City of Portland, Maine - Building or Use Permit Application

Permit No: 2012-65702	Issue Date:	CBL: 030 A001001
--------------------------	-------------	---------------------

Proposed Use: Commercial - Restaurant - 1st & 2nd floors - Poppy's Fish Shack & Oyster Room	Proposed Project Description: Interior renovations for new restaurant 1st & 2nd floors (change of use for 2nd floor), including structural upgrades to beams, columns & wharf bents and 2nd floor exterior deck w/outside dining on both decks (internal demo permit #2012-10-5242)
--	--

Dept: Building **Status:** Approved w/Conditions **Reviewer:** Jeanie Bourke **Approval Date:** 02/08/2013

6 CUSTOM HOUSE WHARF
 PORTLAND, MAINE
 ROOF REINFORCEMENT FOR MECH ROOFTOP UNITS
 ROOF FRAMING PLAN

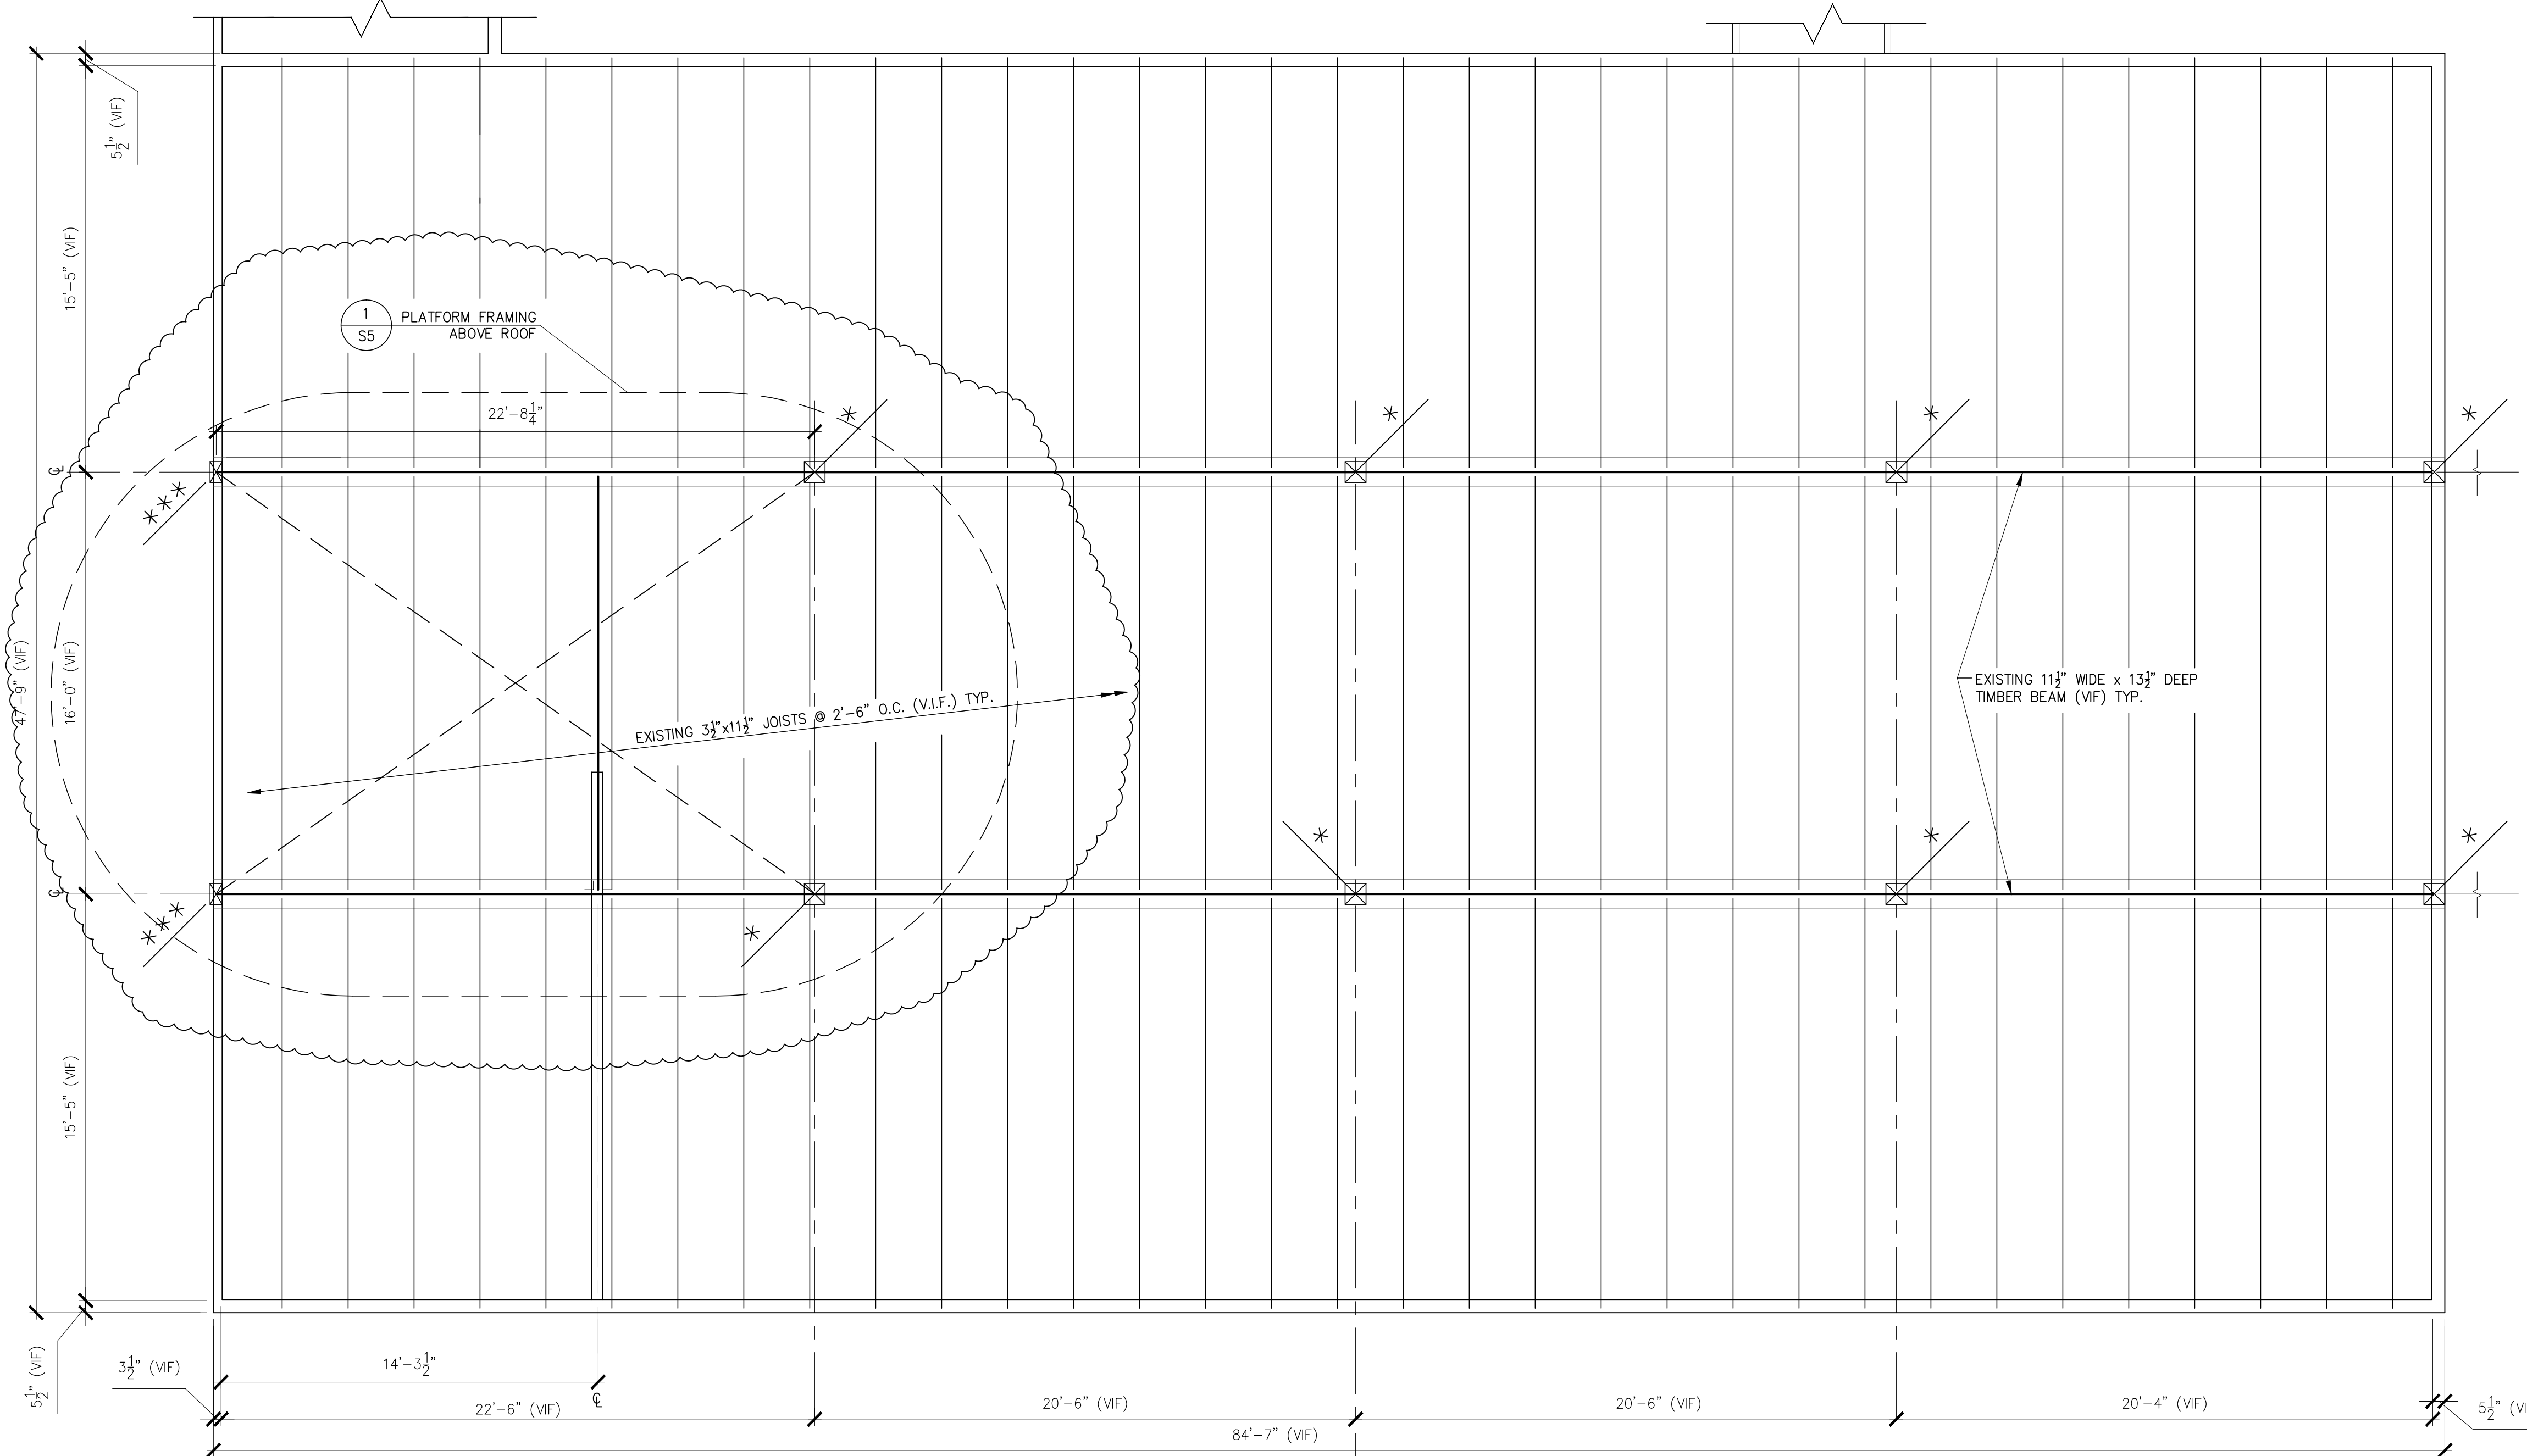
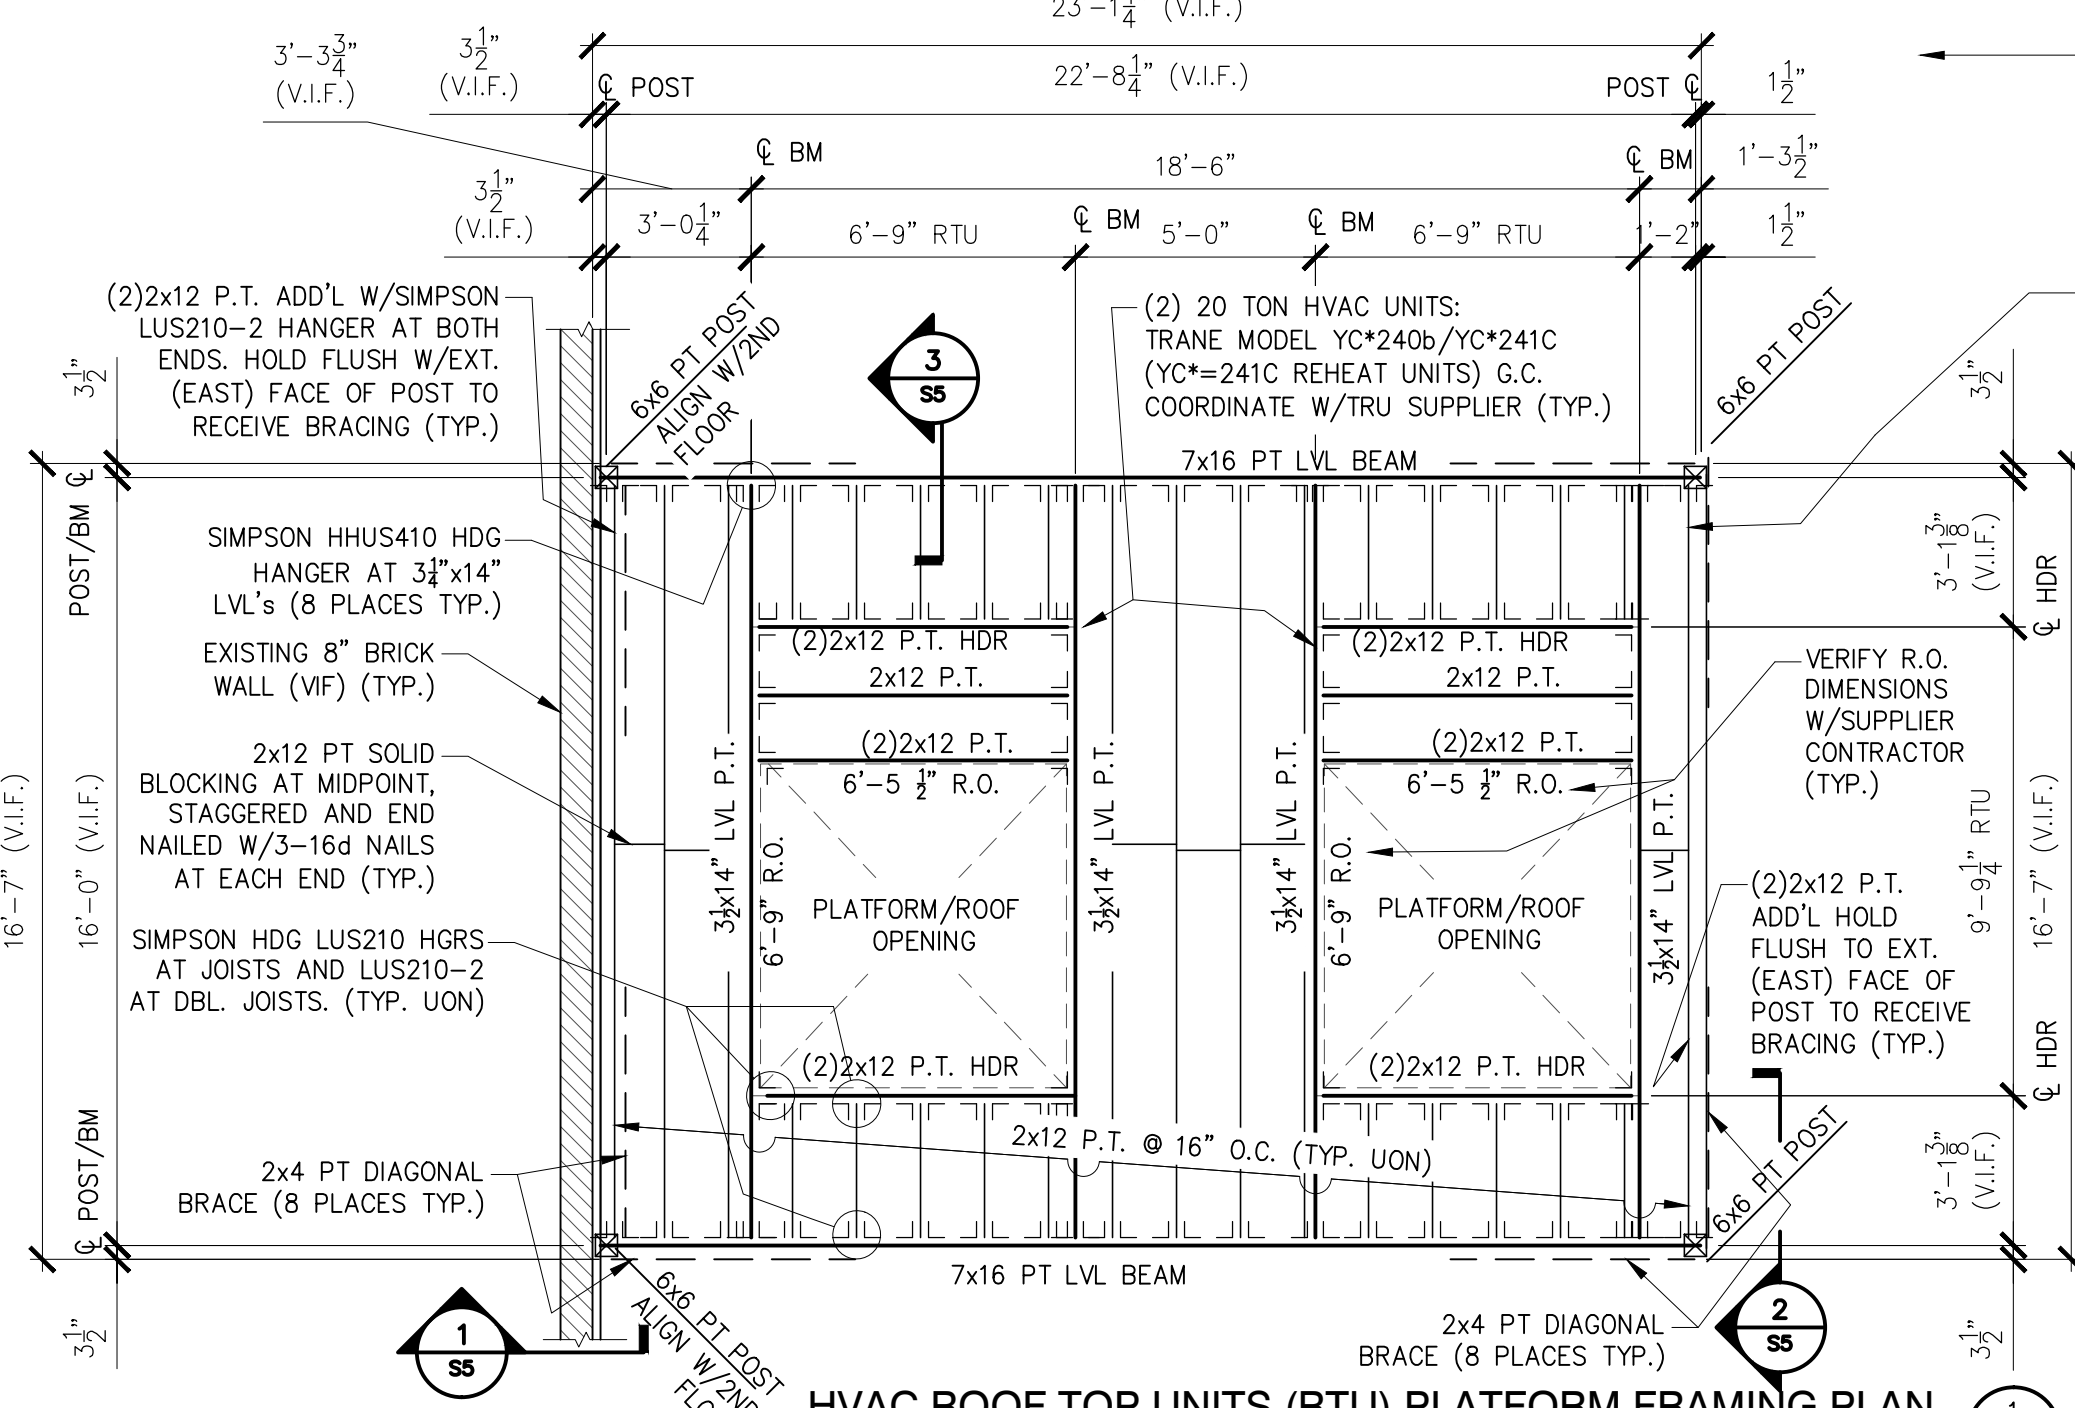
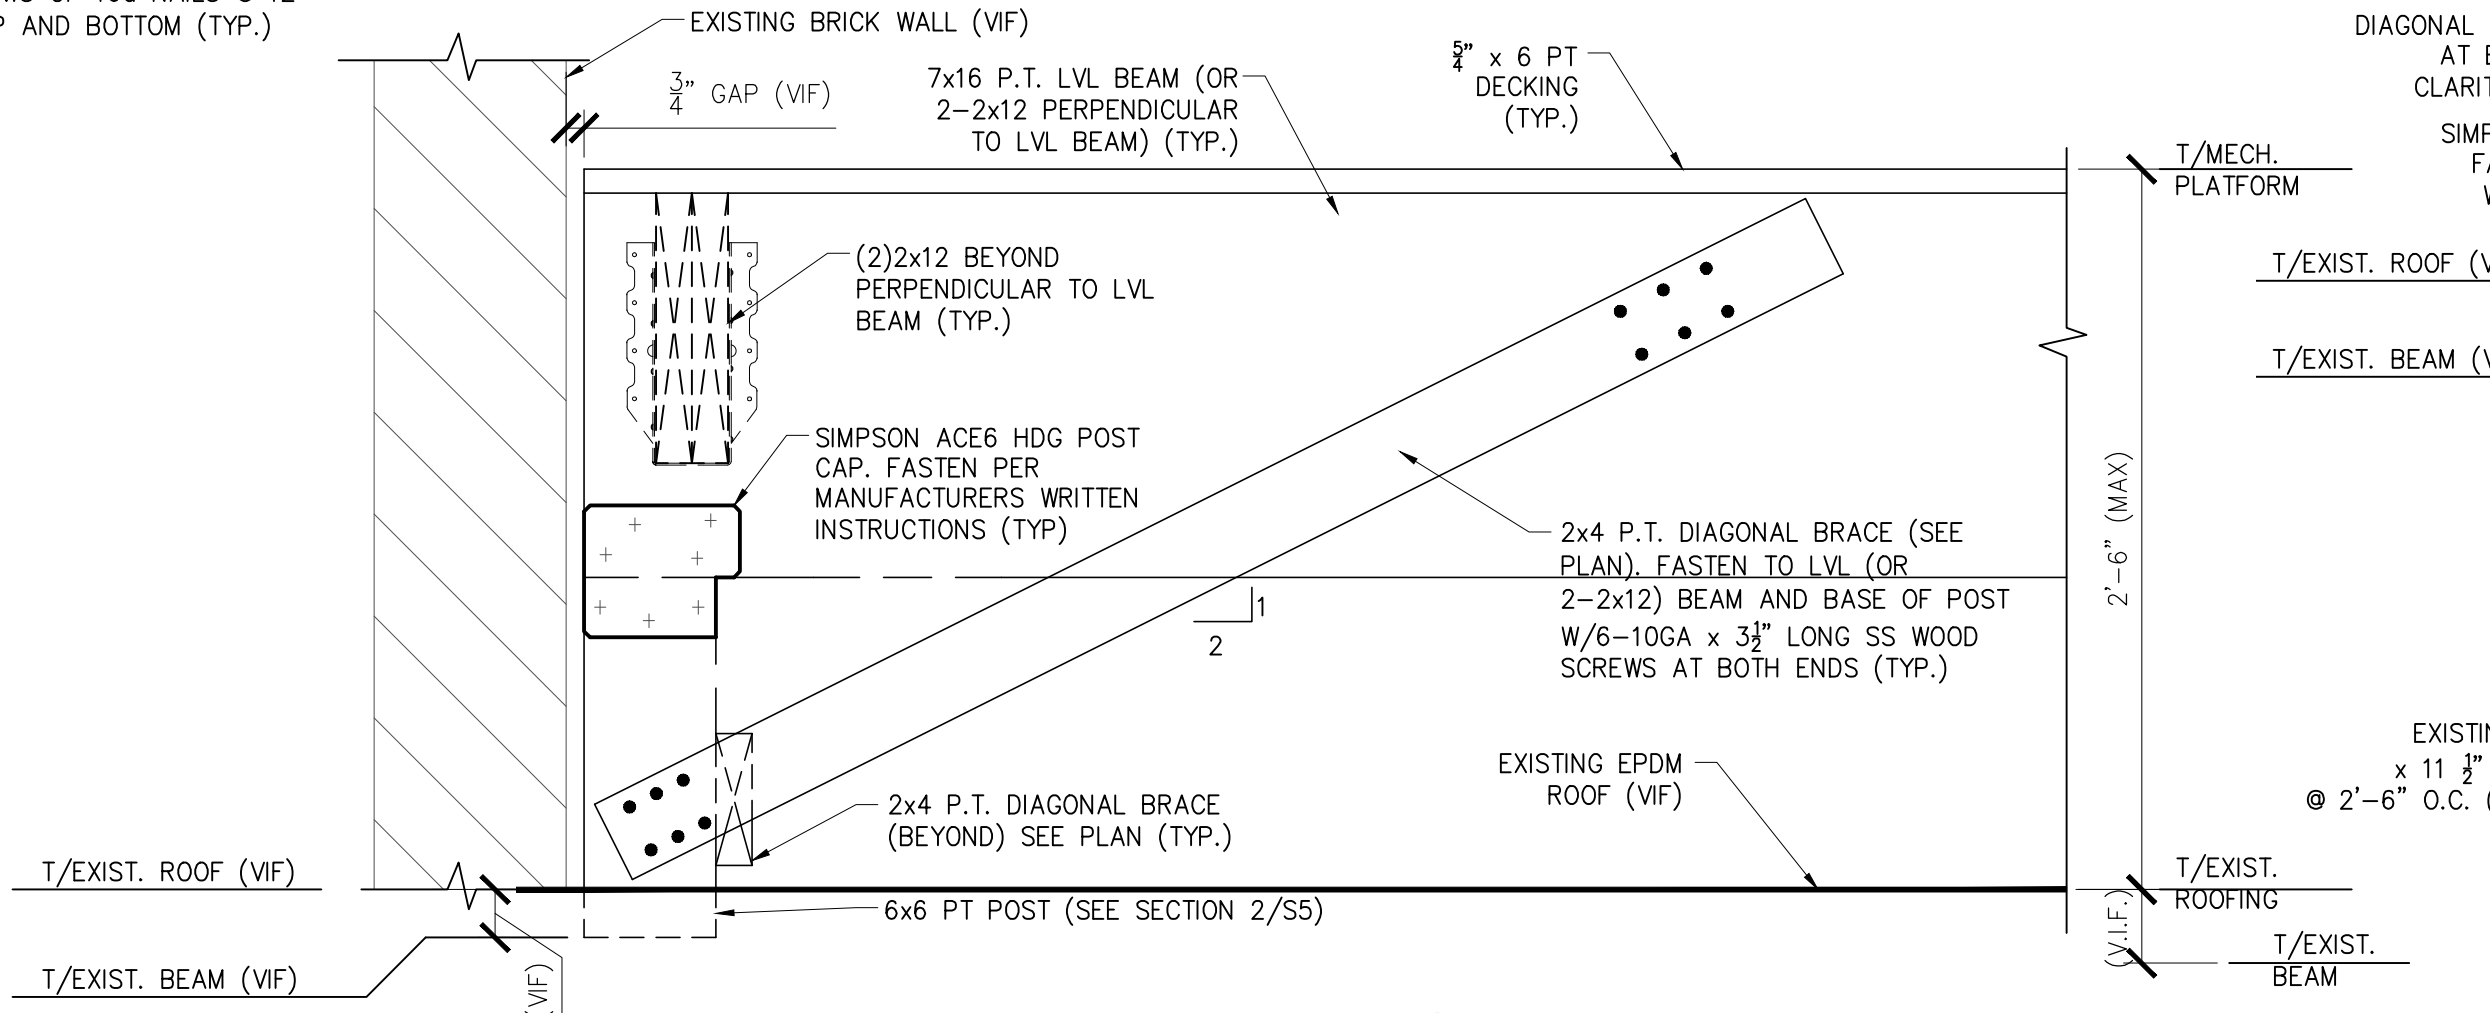
- 11) Framing/structural details for the rooftop platform for the HVAC equipment shall be submitted for review prior to commencement of this work.

4/24/13 See Structural plan S5 for Rooftop Platform
Construction - HVAC equip. JWB
